Your Ref: OWPC26710
Our Ref: EP/37/20/HH 24-03-2020
Please ask for:
Zac Denton

Single storey side/rear extension, part two storey rear extension rear extension, raising of roof height to create a second floor and front double garage.

56 Angmering Lane East Preston Littlehampton

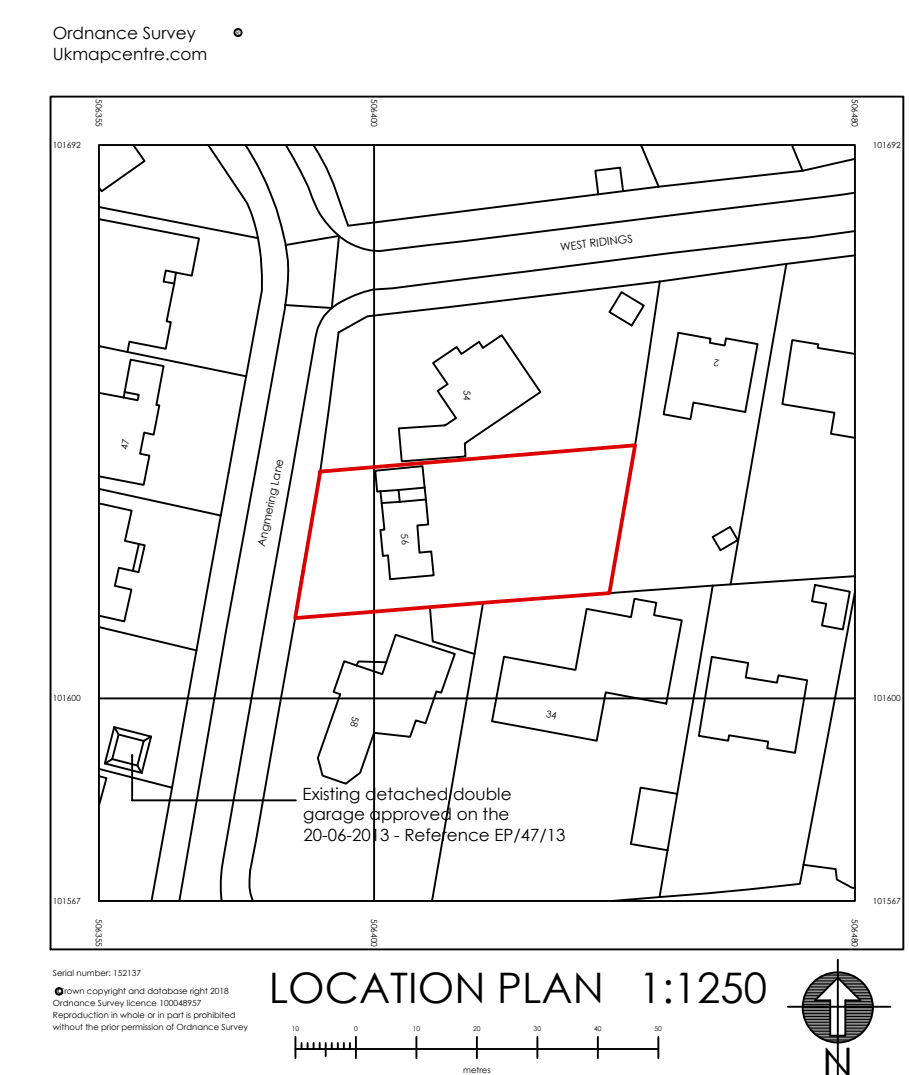
This application describes a house that would be wholly out of character with other houses in the same road or indeed the rest of the Willowhayne Estate, and which would be significantly taller at three storeys. The proposed materials, especially the zinc cladding on the mansard roof, would also be out of character. The proposal can only be described as a model of poor and inappropriate architectural design.

The result is a design that conflicts with the policies of the Arun Local Plan, especially policies D DM1 and DM4, because it does not reflect the character of the surrounding area and does not sympathetically relate to the existing building, but does have an overbearing effect on neighbouring properties; it also contravenes Policy 1 of the East Preston Neighbourhood Plan, because the design, height and materials do not reflect the character and scale of surrounding buildings, in particular because the height exceeds two storeys; it contravenes the National Planning Policy Framework, because it represents poor design; and it contravenes the National Design Guide, because it does not show any appreciation of local character and architectural precedents.
